MORGAN AND MORECAMBE OFFSHORE WIND FARMS: TRANSMISSION ASSETS

Annex 2.2 to Applicants' Response to Deadline 4 submissions from Statutory Consultees and other organisation: Fylde Borough Council (REP4-134)

Deadline: Deadline 5
Application Reference: EN020028

Document Reference: S_D5_2.2

**Figure 1.14: Hedgerows – Section 3**

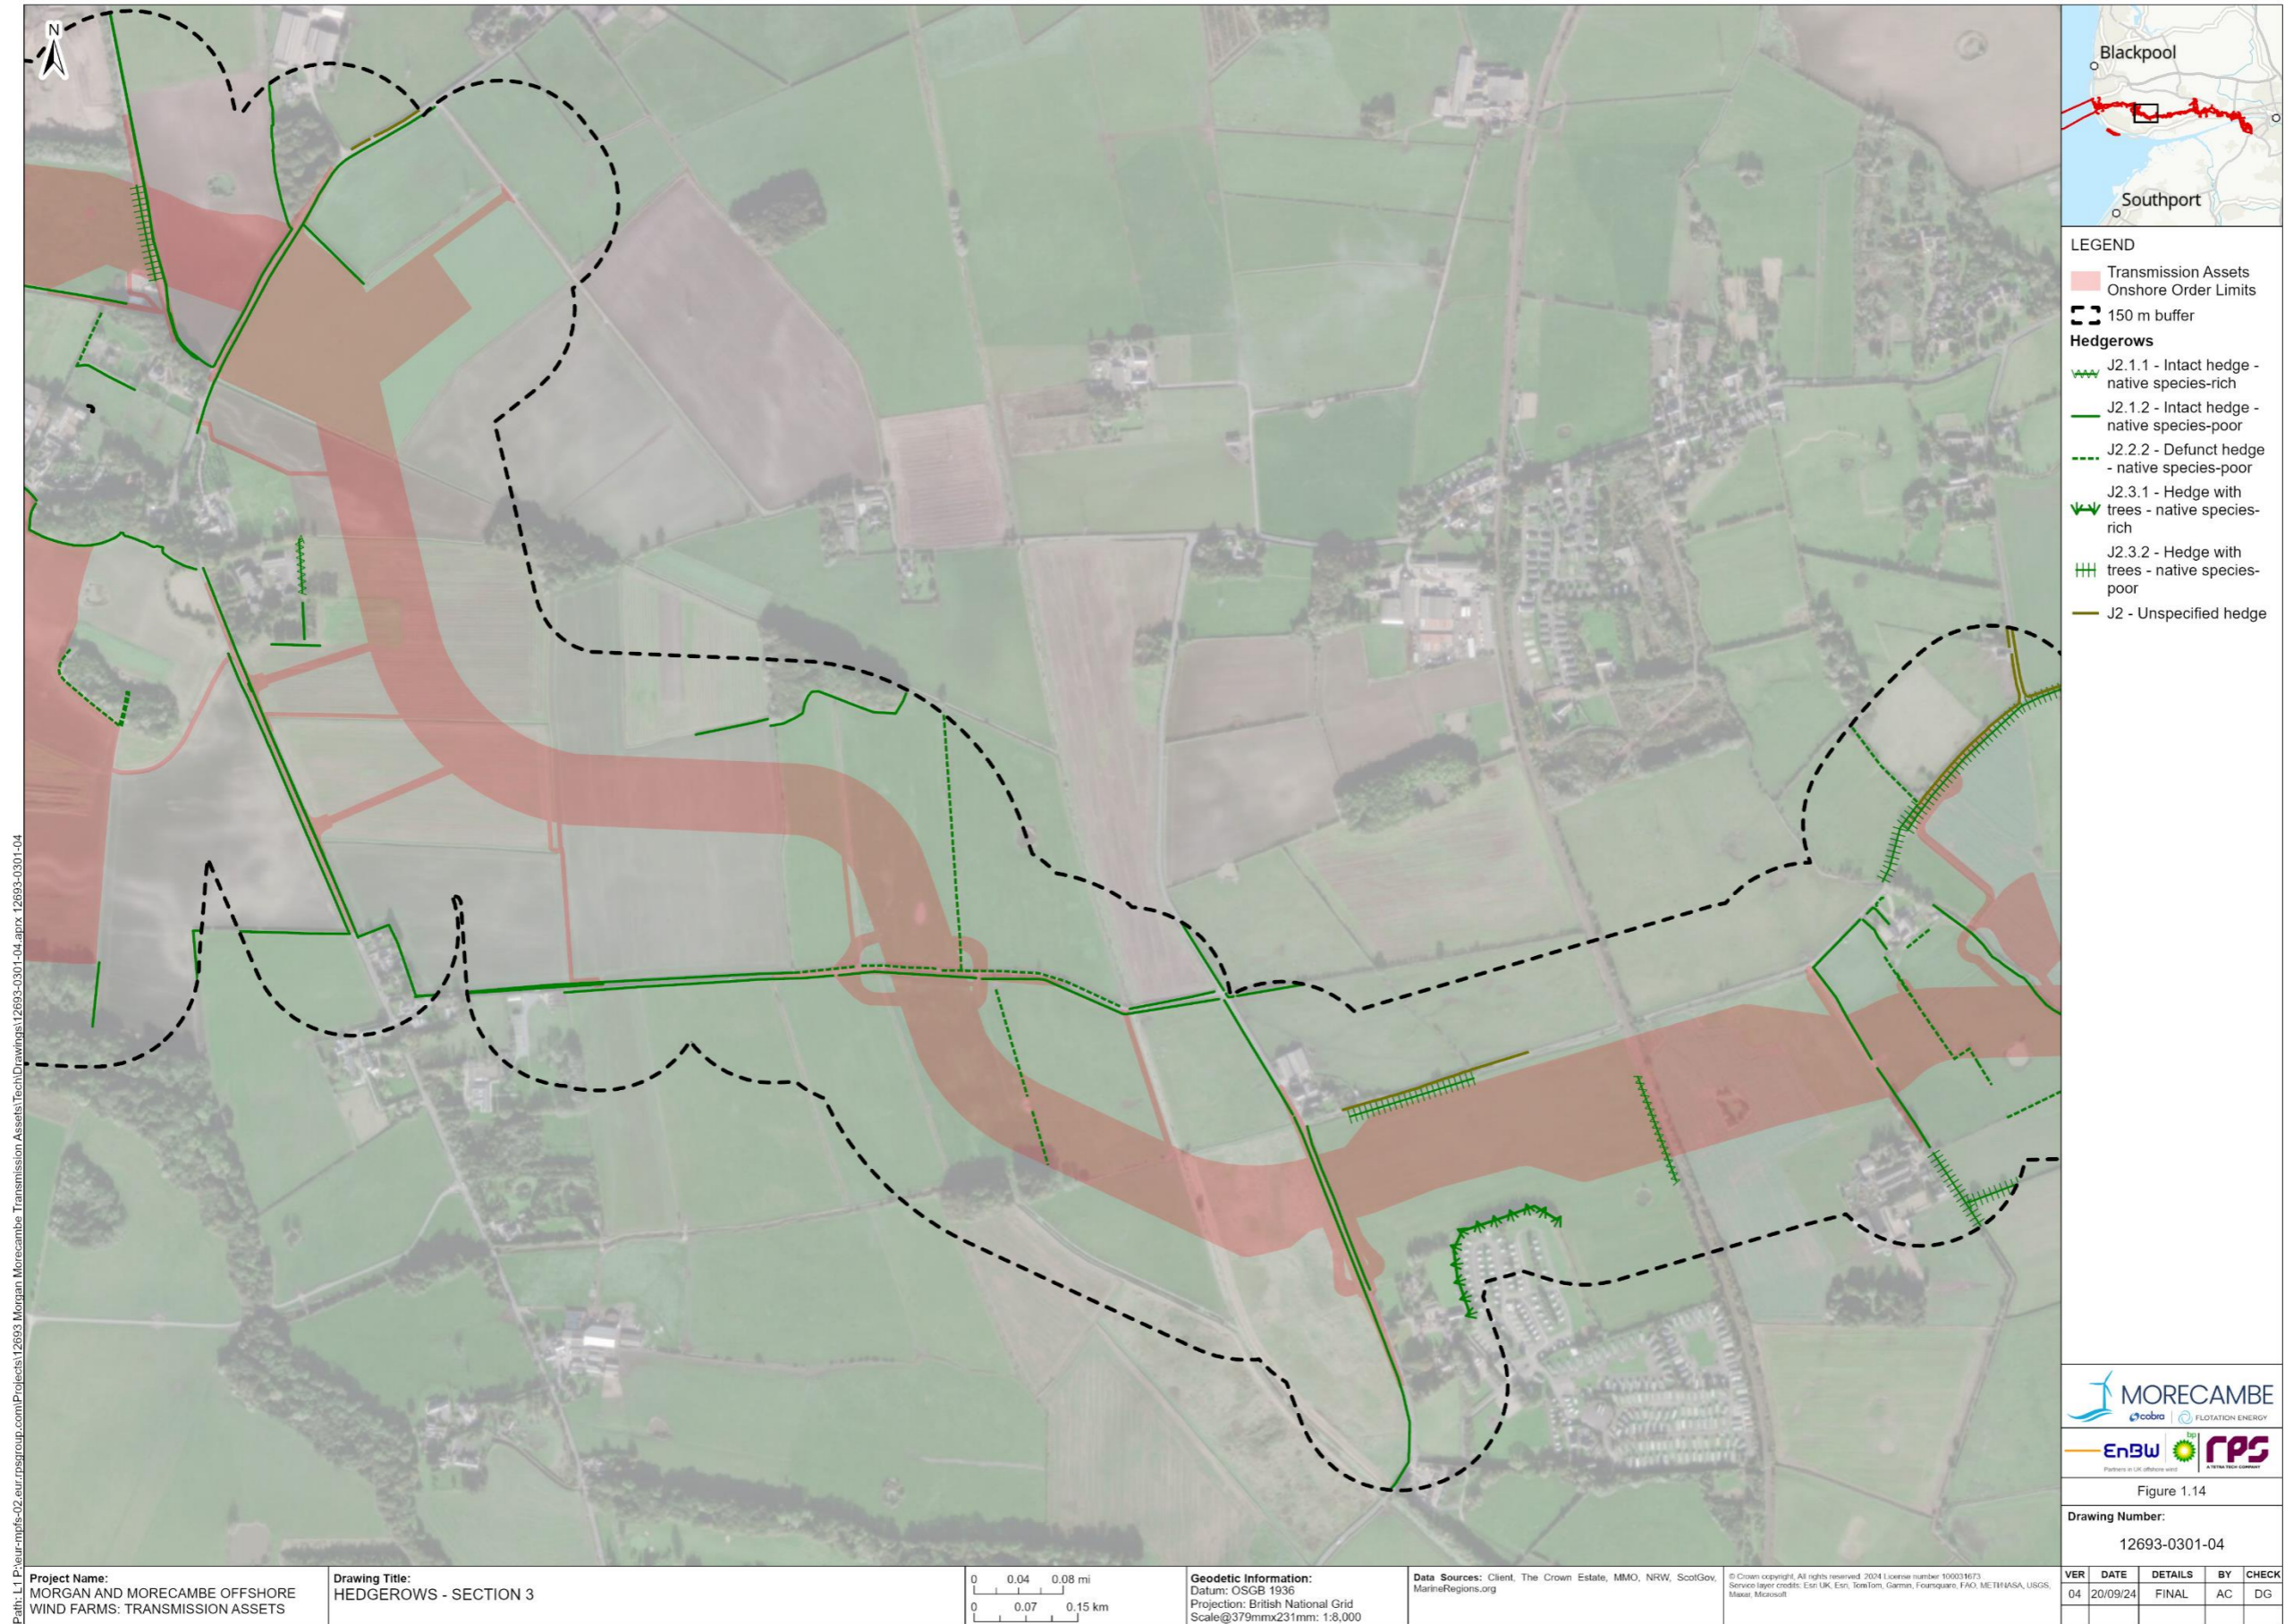
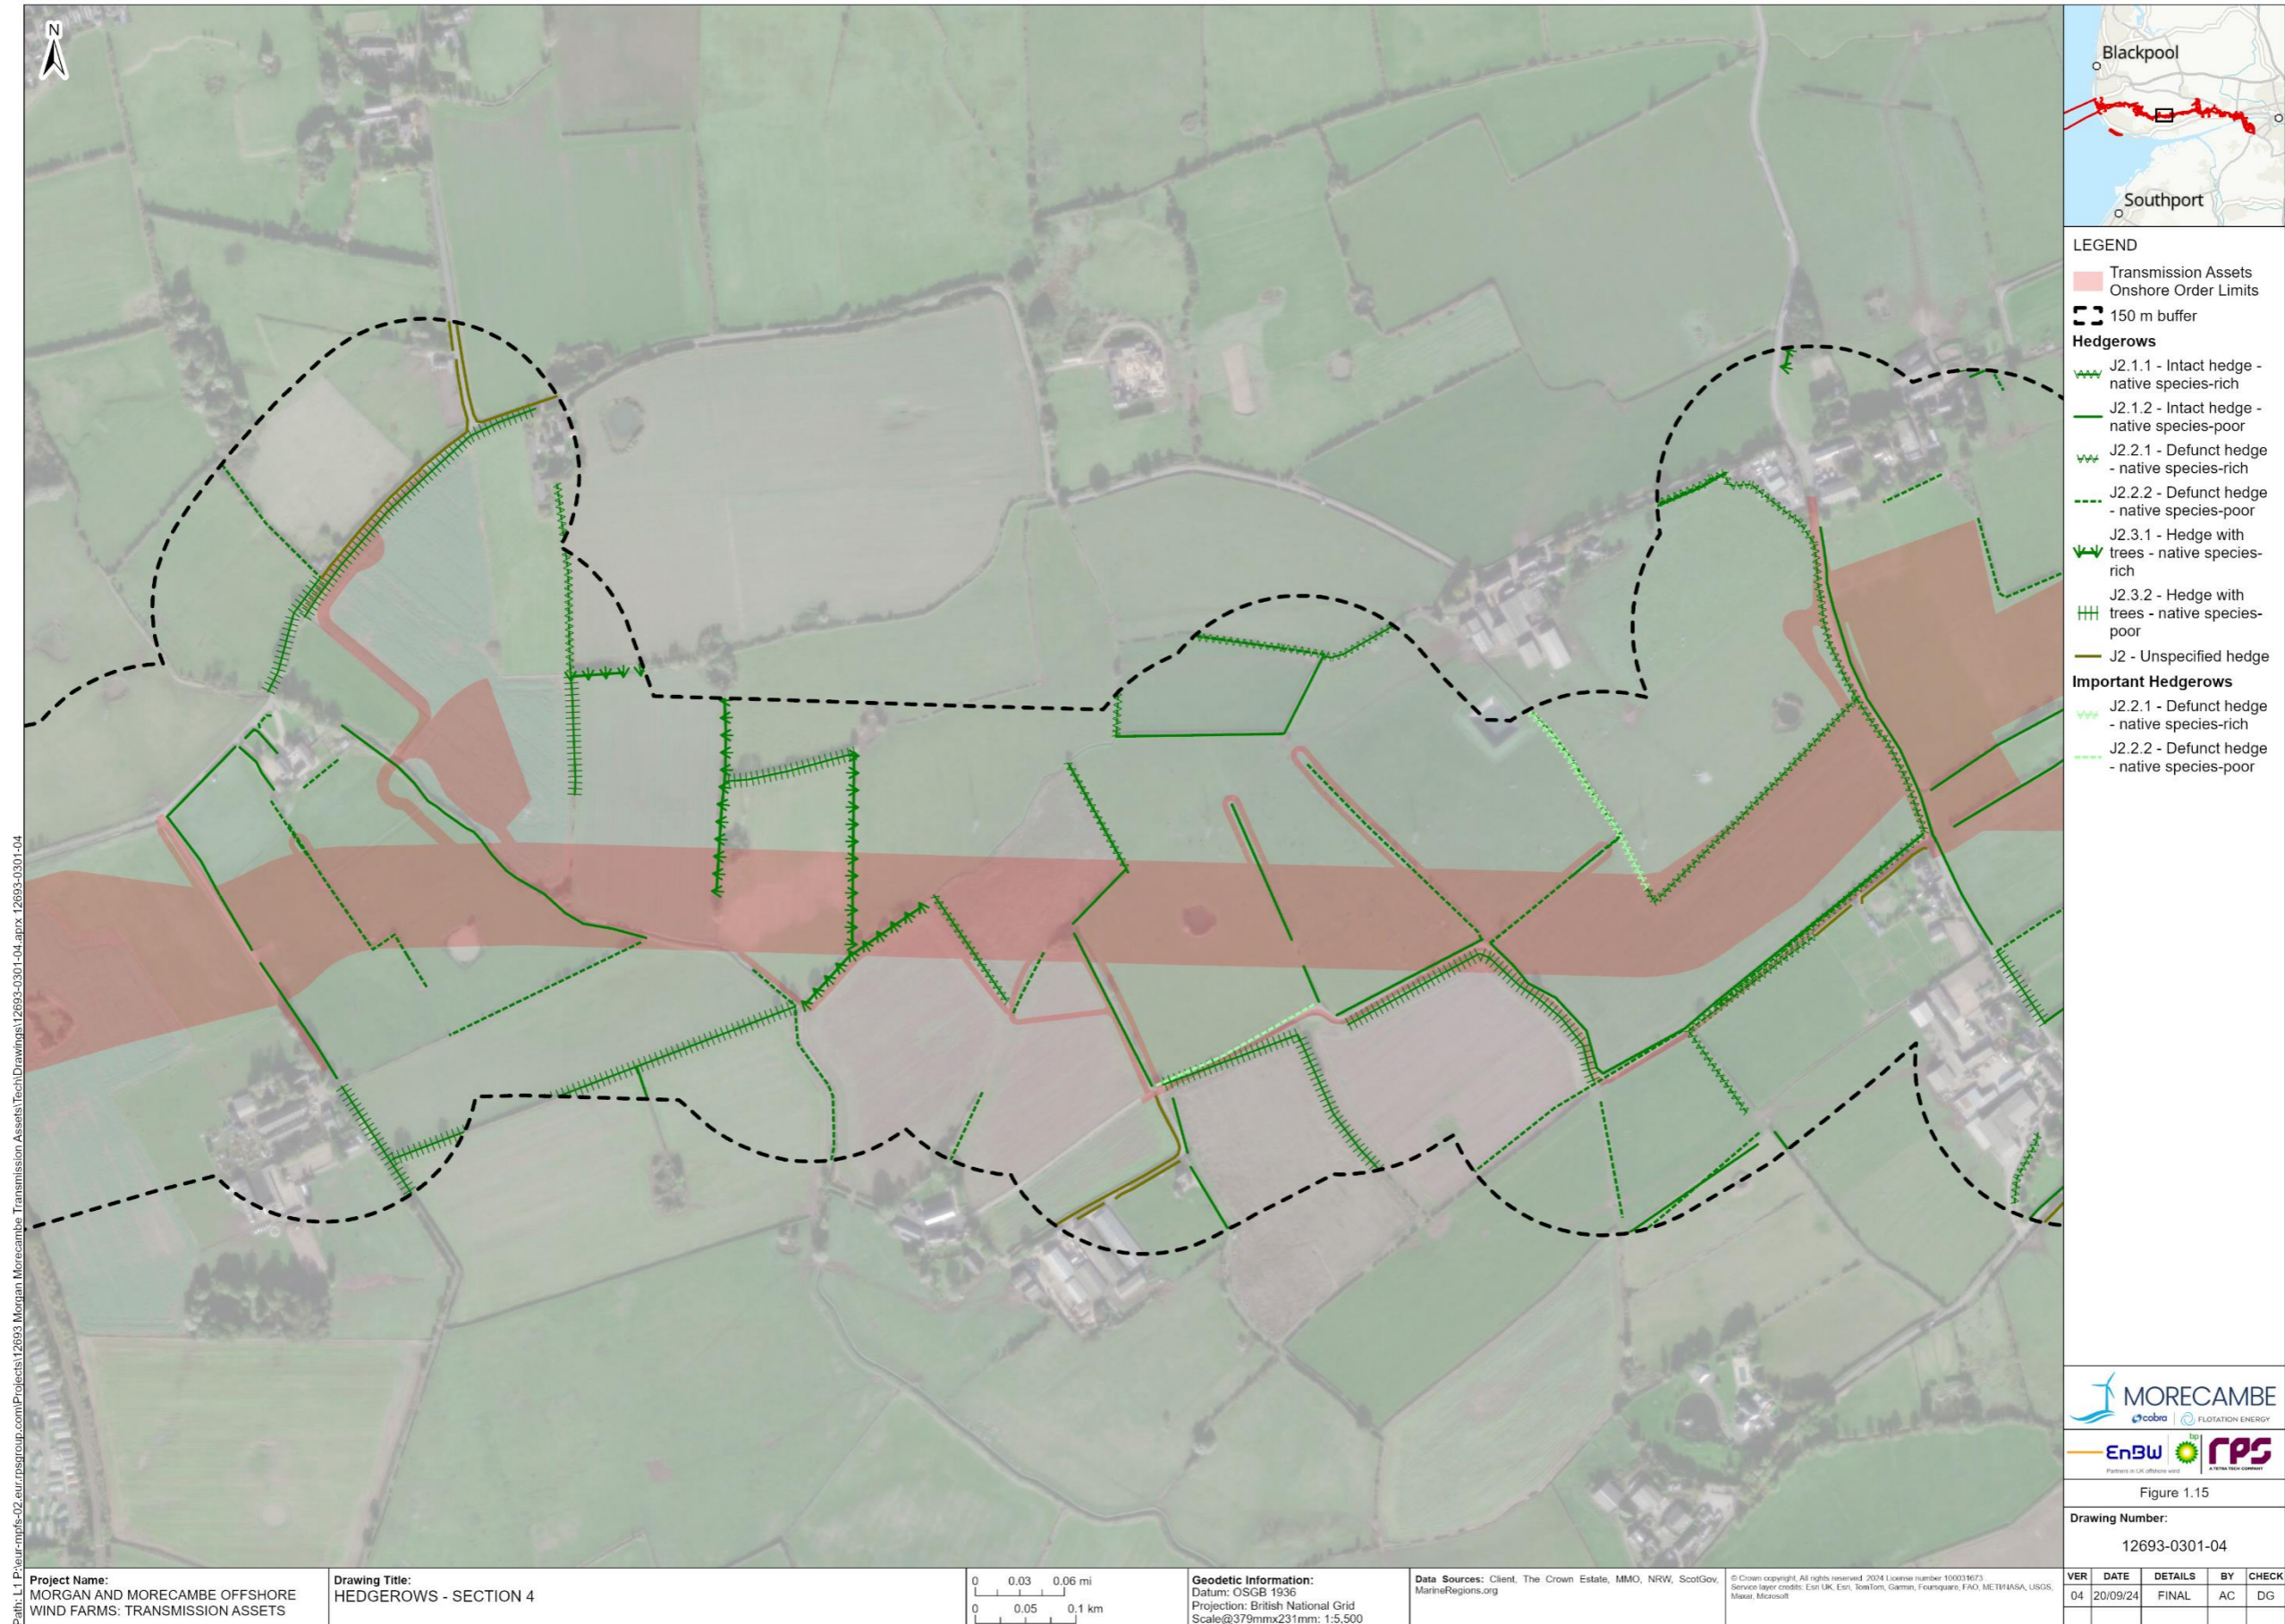
<p>REP4-134</p> <p>134.14</p>	<p>5.2 Scope of Hedge Removal</p> <p>5.2.2 The amount of hedgerow to be removed, as identified in Schedules 11A and 11B of the dDCO [REP3-009] is very large, at approximately 25km total. This is due to the large extent of the cable routing and Order limits significantly resulting in a greater and extended impact.</p> <p>5.2.3 Importantly, Section (4) of Article 35 of the dDCO allows for the removal of any hedgerow within the Order limits, in addition to those identified in Schedules 11A and 11B. FBC considers this to be unwarranted, inappropriate and not in accordance with Good Practice Point 6 of 'Advice Note Fifteen: drafting Development Consent Orders'</p>	<p>The Applicants have reviewed the wording of Article 35 against the Mona Offshore Wind Farm Order 2025 and consider that it is appropriate to update the drafting such that, unless otherwise agreed, Morgan can only remove important hedgerows that are identified in Schedule 11A and Morecambe can only remove important hedgerows that are identified in Schedule 11B. This is qualified by the inclusion of 'unless otherwise agreed', in light of the fact the Applicants have not been provided with full land access across the entire onshore Order limits and therefore it is possible that additional hedgerows may be identified when access to those areas of land is taken post consent. In the case of refusal,</p>

Reference	IP submission	Applicants' response
	<p>which requires all hedgerows affected by the proposed development to be identified within the Schedules.</p> <p>5.2.4 FBC requires that the applicants prepare a Schedule and plan in accordance with Good Practice Point 6 and that Article 36 of the DCO be updated to engage appropriately with these matters.</p>	<p>Morgan/Morecambe would be required to obtain a separate consent for removal of that important hedgerow.</p>
<p>REP4-134 134.15</p>	<p>5.3 Standards for Works to All Trees and Hedges</p> <p>5.3.2 Article 35 of the dDCO [REP3-009] allows for works to trees and hedges, including felling and removal, without any appropriate control.</p> <p>5.3.3 Neither the dDCO, nor the Commitments Register [REP3-013] make reference to any controls or standards in terms of how works under Article 35 would be carried out. A specification of works is therefore required.</p> <p>5.3.4 Section 5.11.27 of EN-1 includes a requirement for existing trees to be retained wherever possible and compensation provided where loss is unavoidable. It is entirely reasonable to extend this principle to require that works to retained trees to be carried out in such a way that harm to the long-term health of those trees is minimised.</p> <p>5.3.5 FBC therefore considers it appropriate to include control either within the DCO or Commitment Register, such as that works should be carried out in accordance with BS3998:2010 and BS5837:2012, and that tree health checks should be conducted by a suitably qualified Arboricultural Clerk of Works to satisfy the monitoring and supervision requirements within BS5837:2012.</p> <p>5.3.6 FBC requires like for like replacement for hedge loss, to achieve this recording of the hedge removal, tree/shrub species and soil types needs to be fully recorded. This is consistent with EN-1, FBC Local Plan Policies ENV1 and ENV3, and 'Advice Note Fifteen: drafting Development Consent Orders'.</p>	<p>The Applicants have prepared an outline Arboricultural Method Statement (S_D5_10) which is secured through Requirement 8 of Schedules 2A and 2B to in the draft DCO (C1/F07). Measures include but are not limited to:</p> <ul style="list-style-type: none"> Any further surveys required would be undertaken in accordance with BS5837:2012 All works to trees shall be carried out in accordance with BS3998:2010 and latest arboricultural best practice. All tree work shall be carried out by suitably qualified, competent and insured arboricultural contractors in accordance with Arboricultural Association Standard Conditions of Contract and Specifications for Tree Works (2008) Edition Measures to ensure tree health is considered and maintained throughout construction (such as construction exclusion zones and tree protection fencing) <p>The Applicants have also updated Section 1.6.3 of the Outline Ecological Management Plan at Deadline 5 (REF) to provide further clarity of the measures that would be in place to ensure the removal of and works to hedgerows are minimised. The measures include but are not limited to:</p> <ul style="list-style-type: none"> All hedgerows and trees retained within, or on the boundary of, construction work areas will be appropriately protected from damage during the construction works. A theoretical root protection area (RPA) is to be calculated, to ensure hedgerows and associated trees are not harmed by development activities

Reference	IP submission	Applicants' response
		<ul style="list-style-type: none"> Ensuring that all hedgerow removal works will comply with 'BS 5937:2012 Trees in relation to design, demolition and construction – Recommendations' Where hedgerow removal is proposed, works will be undertaken under ecological supervision. <p>In addition, paragraph 1.4.2.3 of the Outline Landscape Management Plan (REF) states that one of the main objectives of the landscape proposals is to reinstate land and plant replacement trees, hedgerows and other vegetation where practicable.</p>
REP4-134 134.16	<p>6 Ecology (Excluding dunes)</p> <p>6.1.2 FBC has provided separate comments relating to the sand dunes area within this written response.</p> <p>6.1.3 FBC notes the Action Points arising from ISH2 and ISH3 as they relate to ecology and will review the new and updated information as it becomes available. FBC expects to provide further written submissions, particularly in response to the range of Outline Management Plans relevant to ecological matters.</p> <p>6.1.4 FBC will also continue to engage with the applicants on matters relating to ecology. FBC can confirm that a series of meetings have been schedule ahead of Deadline 5 which should allow a substantively complete Statement of Common Ground [SoCG] to be submitted at Deadline 5, insofar as it relates to ecology.</p> <p>6.1.5 However, FBC also notes ongoing engagement between the applicants and key ecological consultees, notably Natural England and the Environment Agency. FBC notes with some concern the range of outstanding issues, including in relation to matters which have been a point of either disagreement or slow progress since at least 2023.</p> <p>6.1.6 The remainder of this section provides a summary of oral submission made by FBC at ISH2 and ISH3 as they relate to ecology.</p>	<p>The Applicants can confirm an SoCG meeting was held with Fylde on 5th September.</p> <p>The Applicants can confirm that there is ongoing engagement with EA and NE to discuss these matters. We consider this level of engagement to be typical of a project of this type and size and not anything of concern. Progress has been made on these issues and we do not consider this to be slow.</p>
